Thank you for consulting us regarding this discharge of conditions application. We have the following comments regarding condition 3.

Application No: M/130/21/DOC
Registered: 4th October 2021
Site Address: 8 Manor Way Elmer Middleton-On-Sea PO22 6LA
Description of Works: Approval of details reserved by condition imposed under ref M/86/20/PL relating to Condition No 3 - surface water drainage.

CLIENT		George Bevis	
PROJECT		Manor Way Elmer	
TITLE		Proposed Surface Water Plan	
DRAWN	DATE	PROJECT NO.	
PR	Sept 2021		23605
ENGINEER	CHECKED	DRG. No.	REV.
MK	MK	201	
SCALE			
As Shown @ A1

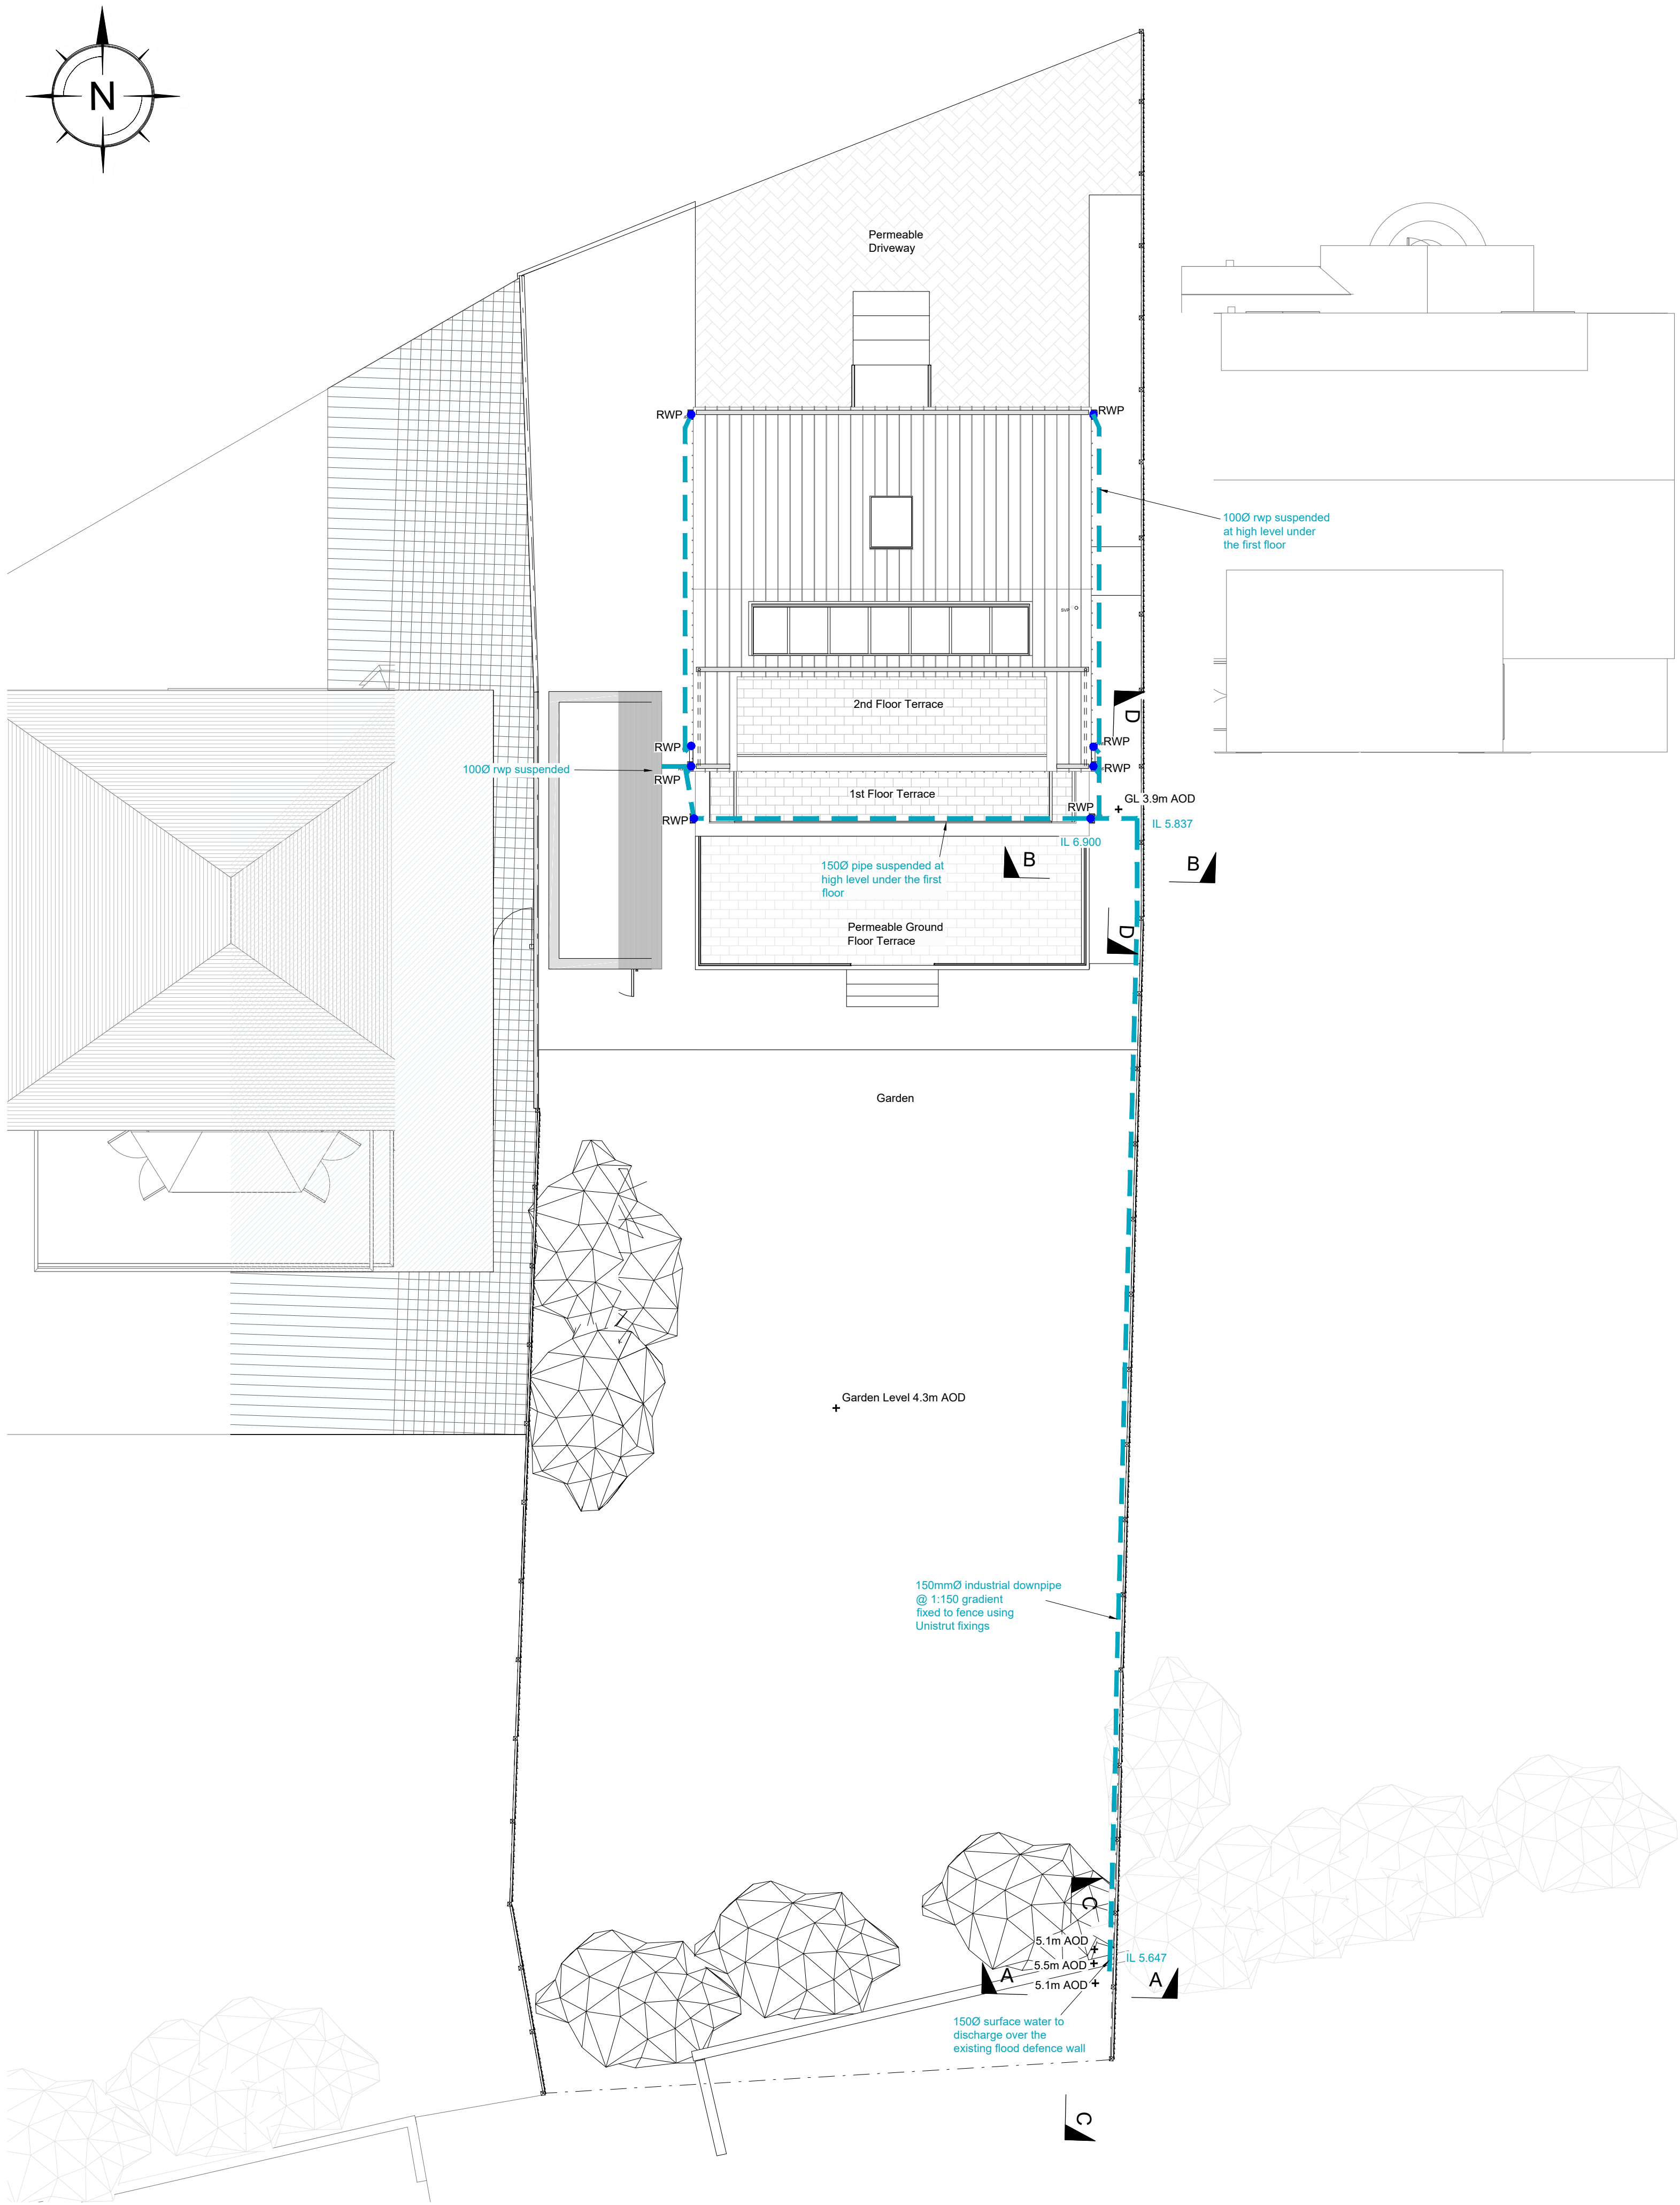
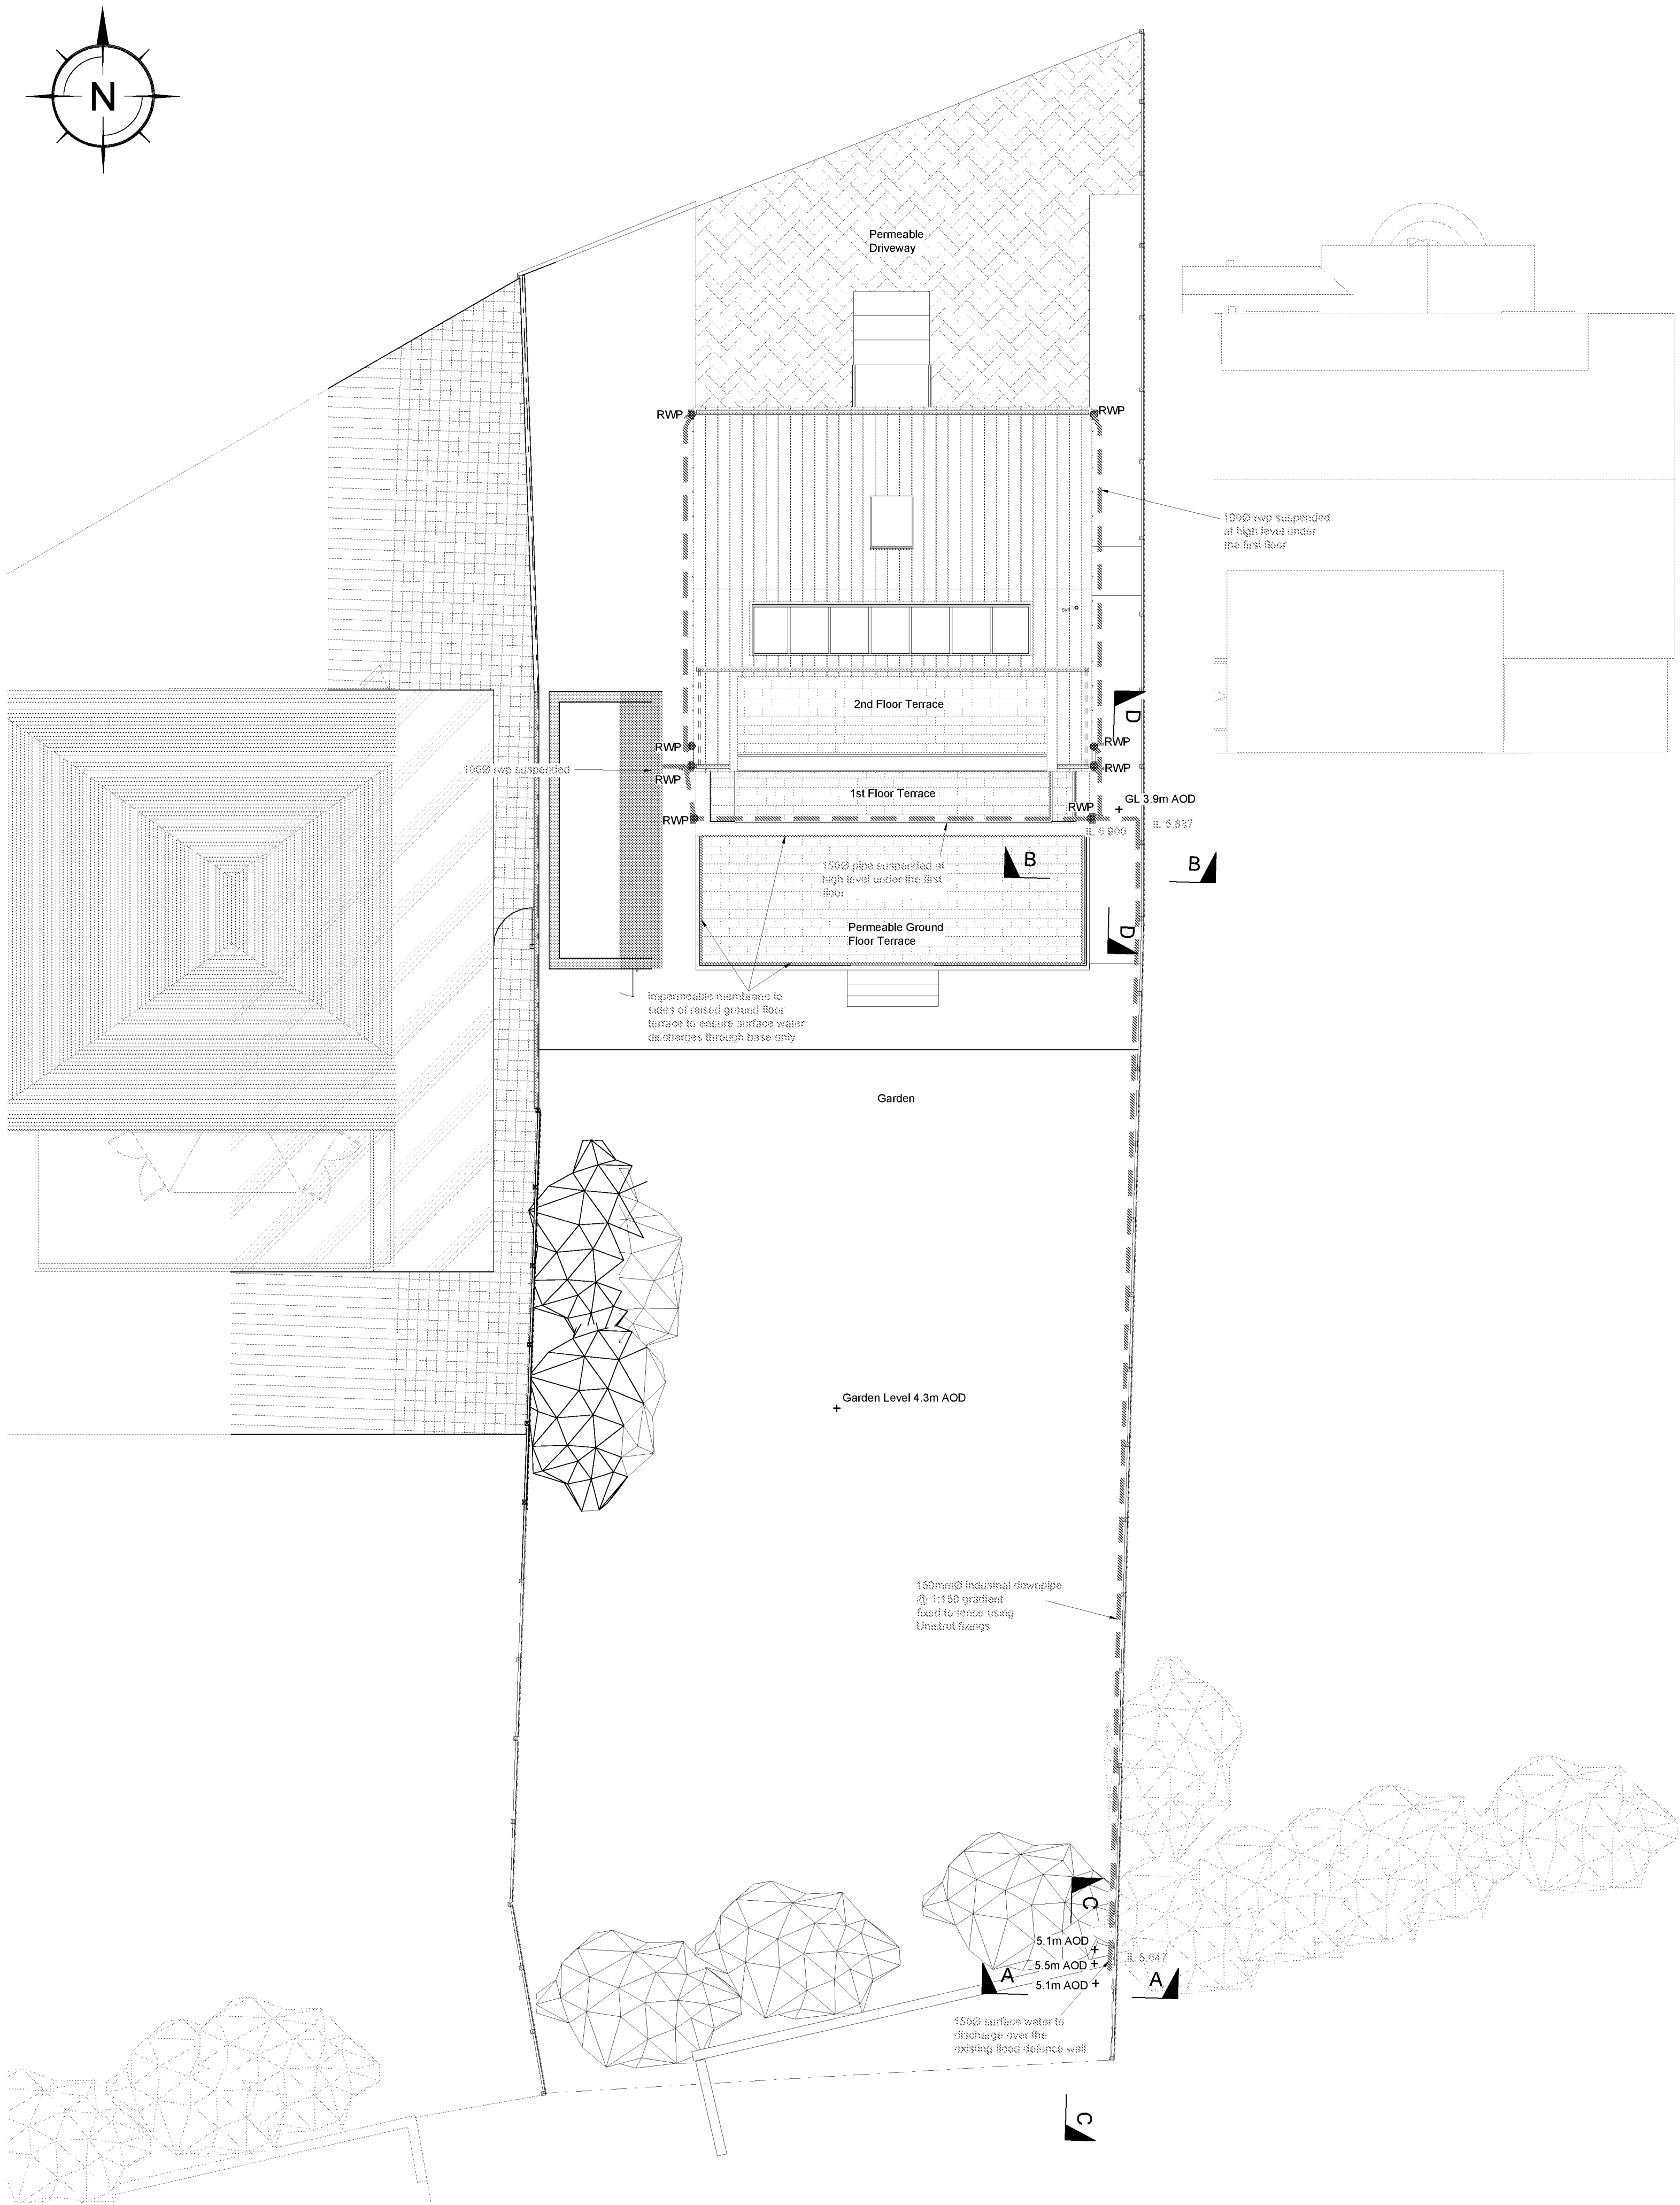
Please can an impermeable liner be provided to the sides of the rear garden ground floor terrace to ensure that water does not travel through the sides of this raised area and infiltrates through the bottom only.

Further to Laura's comment we have added an impermeable membrane to the sides of the rear garden terrace area on drawings 201A and 501A, copies attached. I trust this will allow the surface water scheme and Planning Condition 3 to be discharged.
